**Consultation Response from Emma Mills  
 KC Landscape**

<b>Application No:</b>	2023/90531
<b>Proposed Development:</b>	Demolition of existing warehouse building and erection of mixed-use retail warehouse (Use Class B8), showroom (Ea) and office (B2)
<b>Location:</b>	Highgate Beds Ltd, Bretton Street, Savile Town, Dewsbury, WF12 9DB
<b>Applicant/Agent:</b>	PARKdesigned Architects
<b>Planning Officer</b>	RichardA Gilbert
<b>Date Responded:</b>	20 <sup>th</sup> June 2022
<b>Responding Officer:</b>	AR
<b>Responding Ref:</b>	MM32

Proposed Site Plan

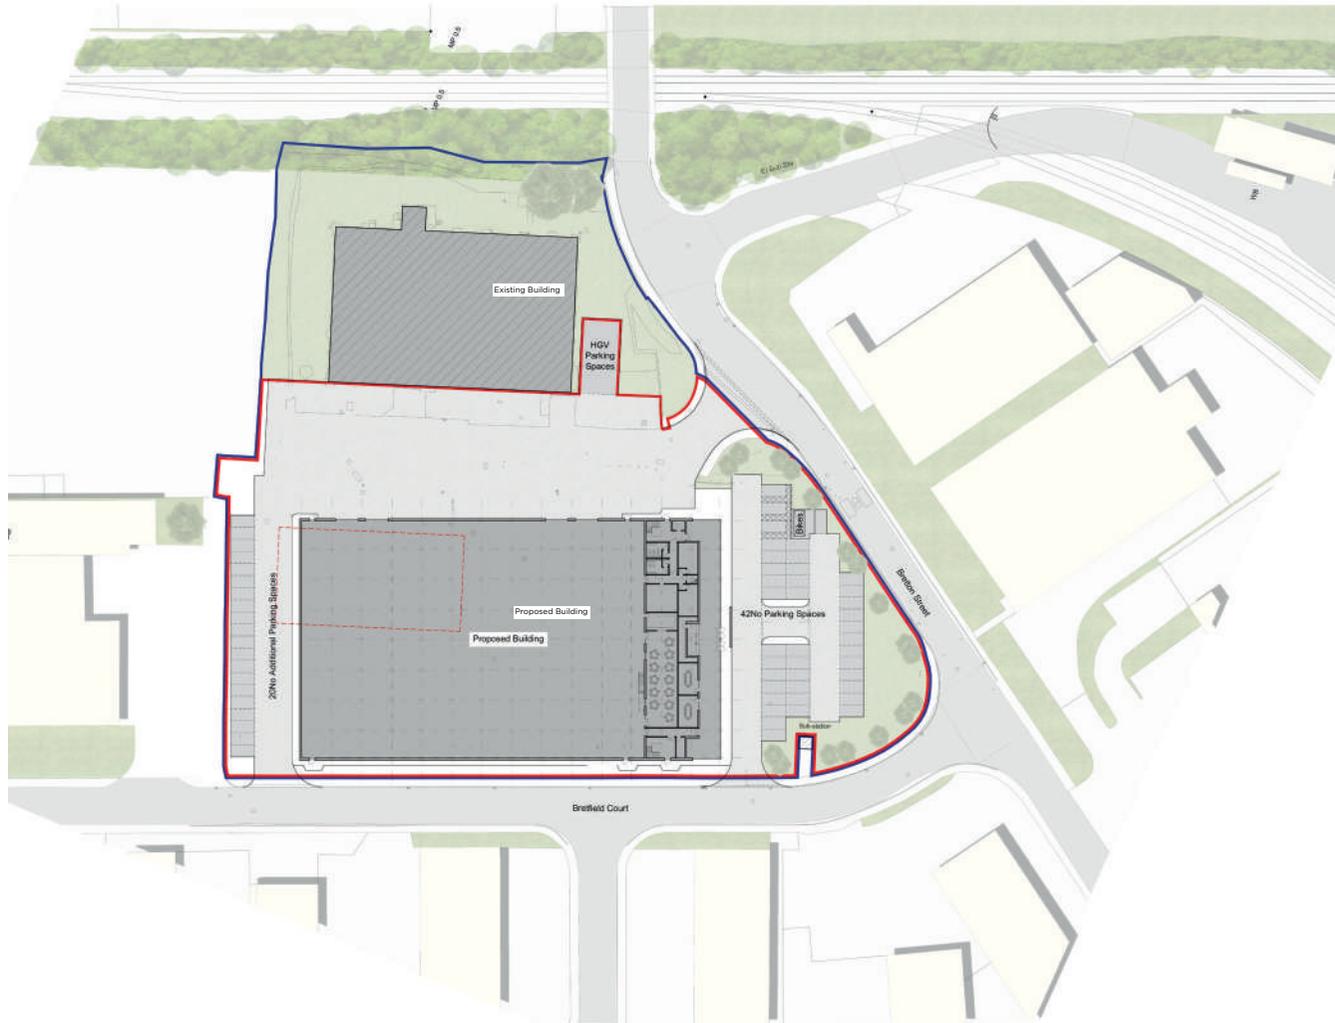
- The adjustments to the proposed landscape layout are appreciated, particularly the addition of native hedge, indicated as running parallel to Bretfield Court road. However, the provision is tokenistic, we do not consider this a significant or robust green boundary. Until recently there has been a thriving green margin to this site providing a strong visual green screen and a valuable wildlife bridge/resource. The impact of the proposed structure will be significant, and the loss of this green has a distinctly negative impact on an area already lacking in vegetation. This impact can be greatly reduced by moving the mass (structure) further back from the road allowing for a wider margin of green structure to be incorporated into the scheme. This would enhance both the street scene and soften the mass of the façade whilst adding/retaining a valuable and effective wildlife corridor within the site in replacement of the green structure recently removed. We would propose further tree planting in combination with the proposed native hedge.

6. The planting scheme to Bretton Street is also much improved and we welcome the additional trees.  
The planting schedule is not comprehensive so we are therefore not able to comment on the planting at this time and will require a full planting schedule.
